DRB CASE ACTION LOG - BLUE SHEET

Project #: 1009595

Project Name: Fairgrounds addition

**CITY OF ALBUQUERQUE  
PLANNING DEPARTMENT  
February 27, 2013  
DRB Comments**

**EXHIBIT**  
**Lot 6-A-1, Block 14**  
**Fairgrounds Addition**

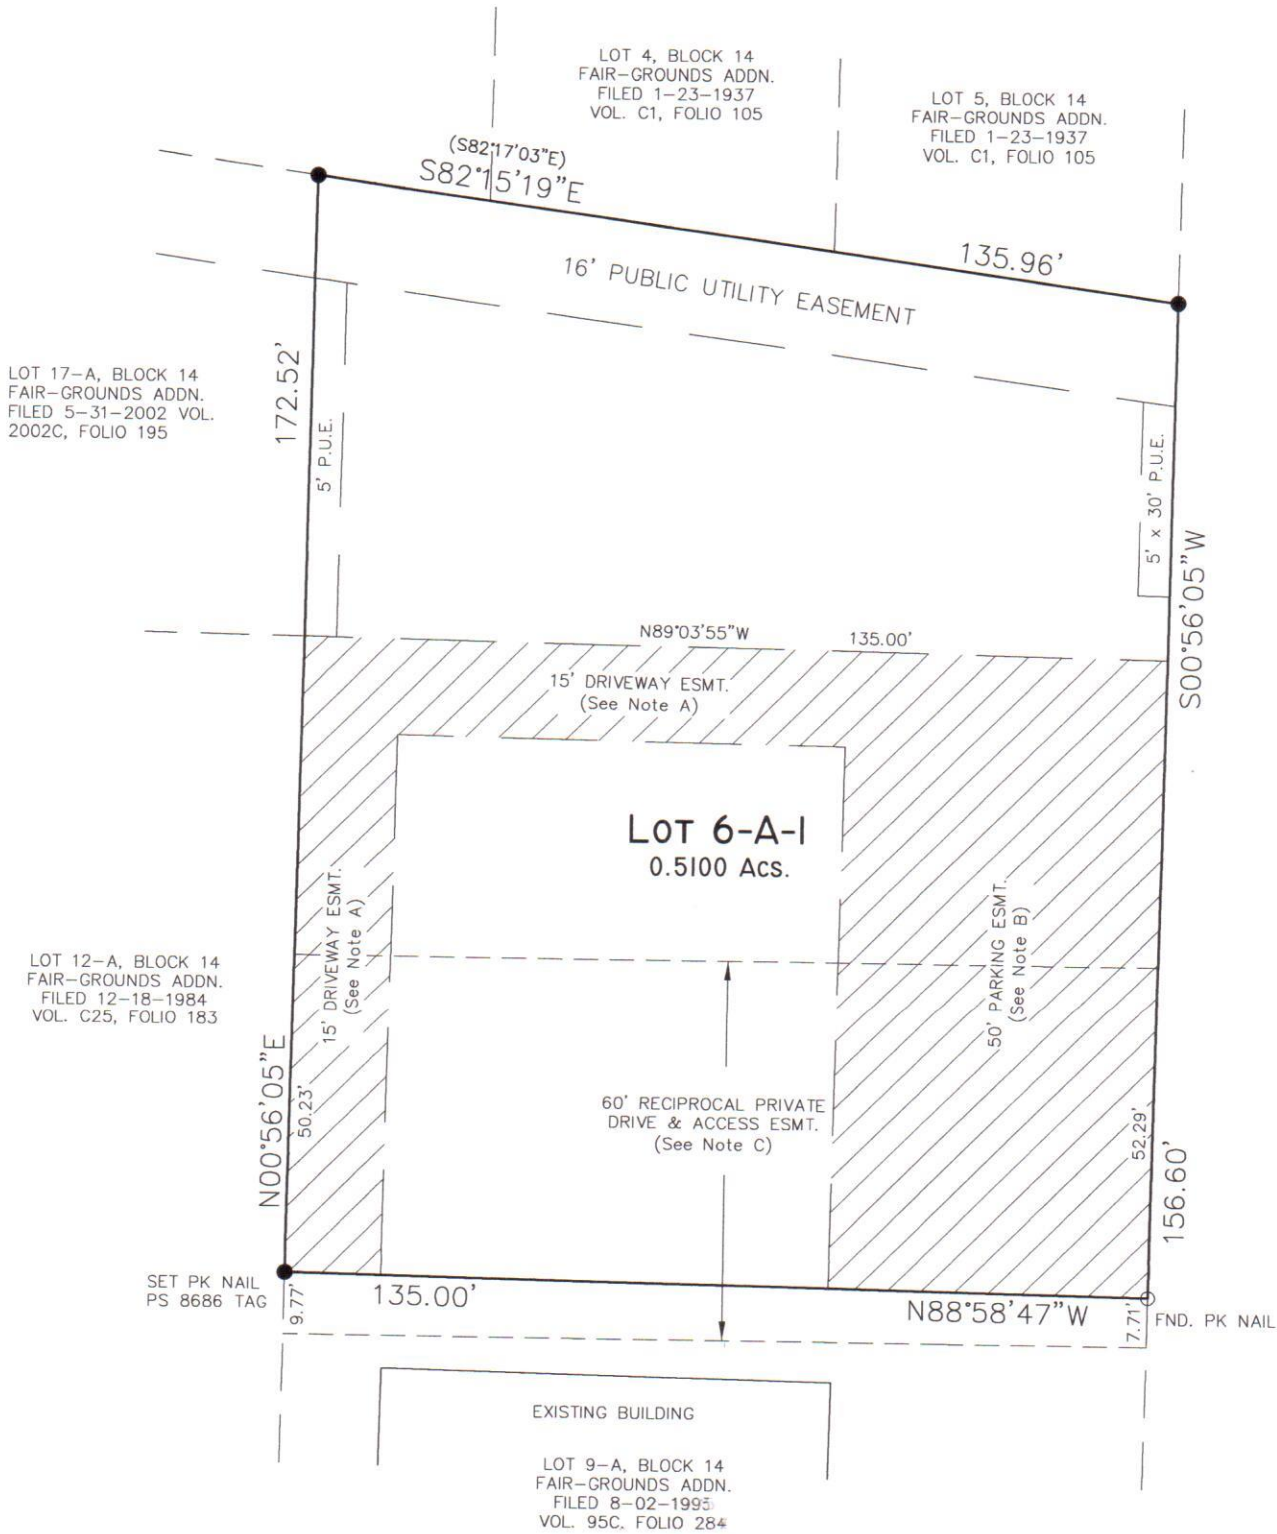
All beneficiaries of the easements proposed for vacation must agree in writing – this would include the owner of Lot 9A to the south of this site.
